Subject: Ref R/184/17/PD

Application for change of use of 51 Sea Lane from class A1 shop to class A3 Restaurants & Cafes.

**APPENDIX ONE:
DRAWING SHOWING EXTERNAL EXTRACT AND VENTILATION EQUIPMENT PROPOSED**

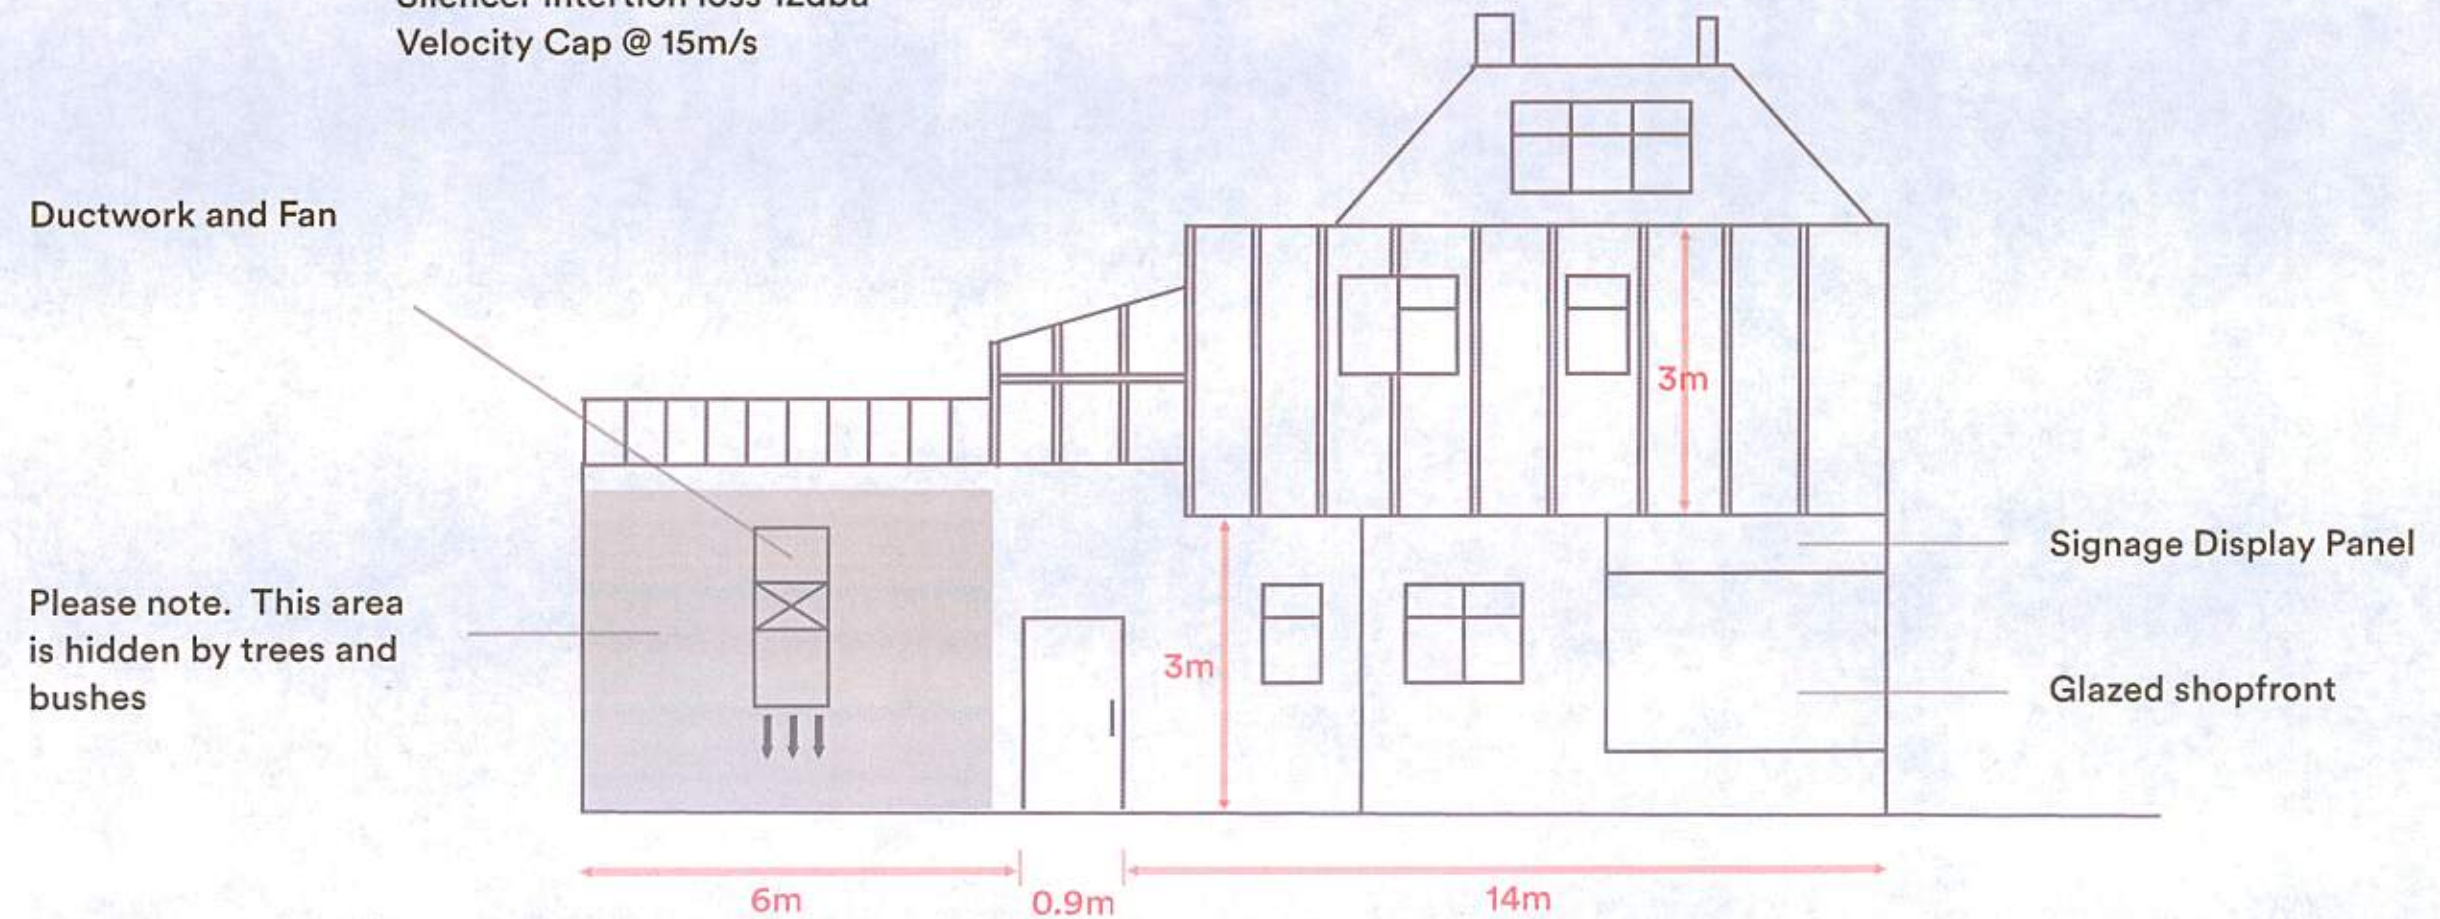
The positioning and use of a venting system for the proposed kitchens, which are according to the plans to be hidden by trees. Surely this then proposes a fire risk, particularly as the houses directly opposite the side entrance to number 51 is thatched. Secondly such a venting system would produce noxious odours and considerable noise.

APPENDIX TWO:
DRAWING SHOWING PROPOSED REFUSE FACILITIES

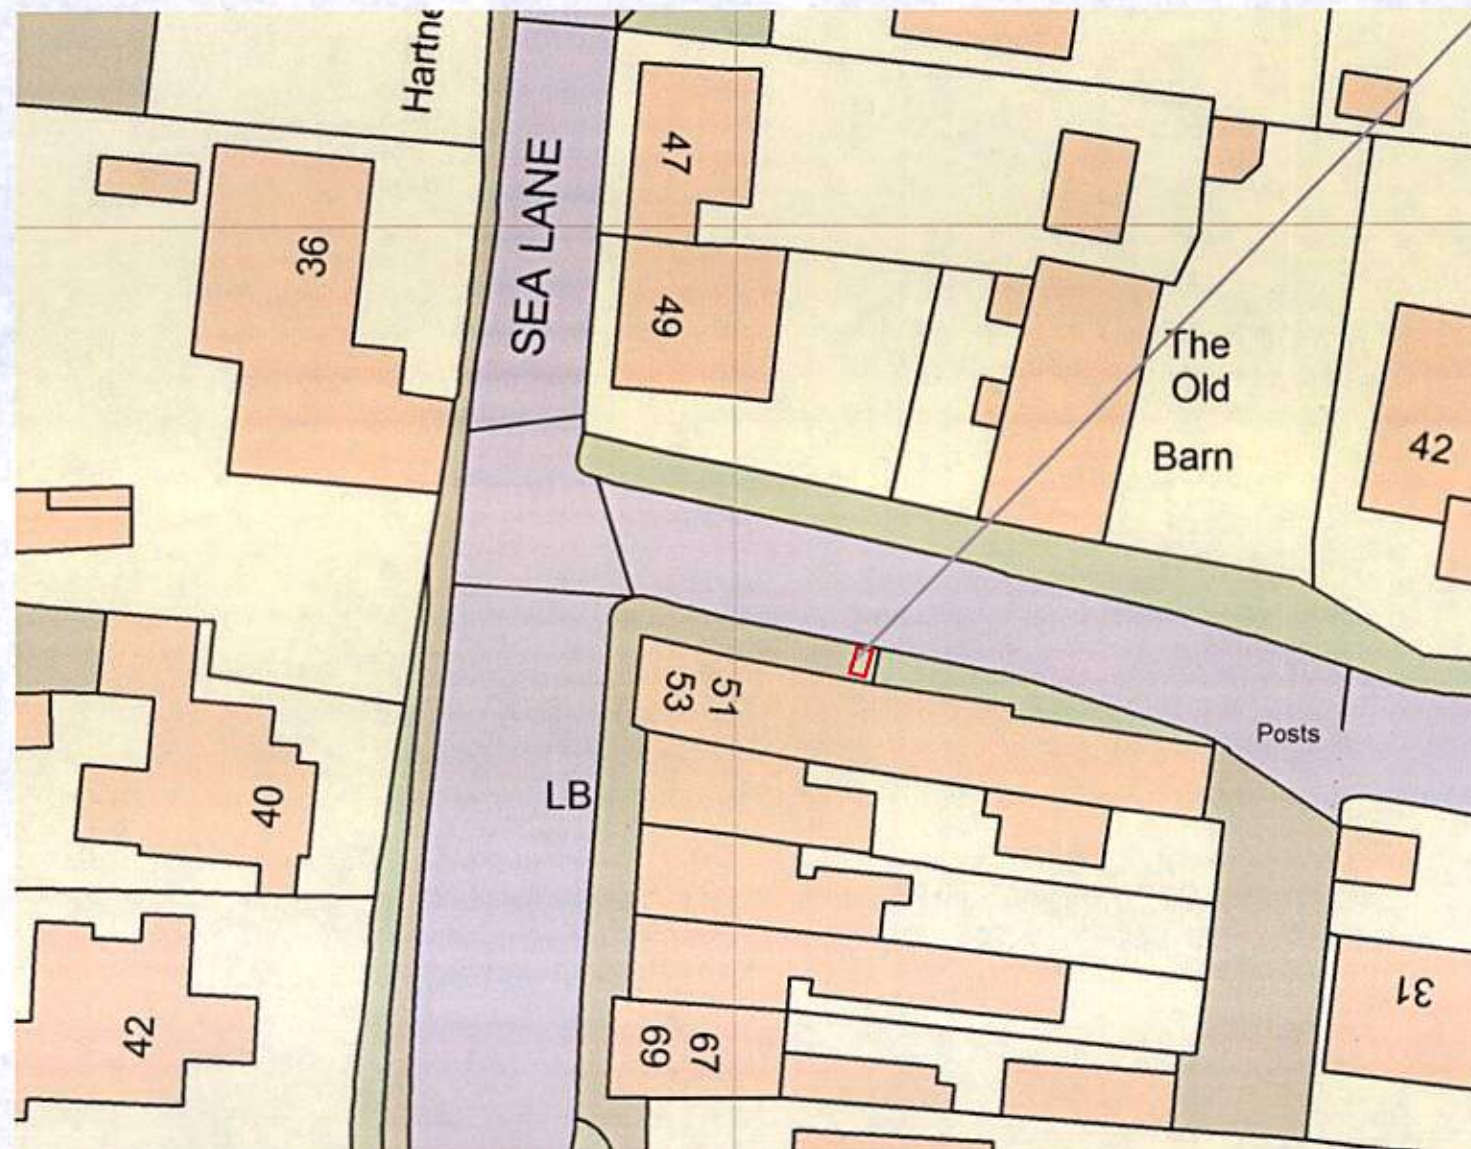
The potential for increased rubbish that will attract vermin with the attendant health concerns.
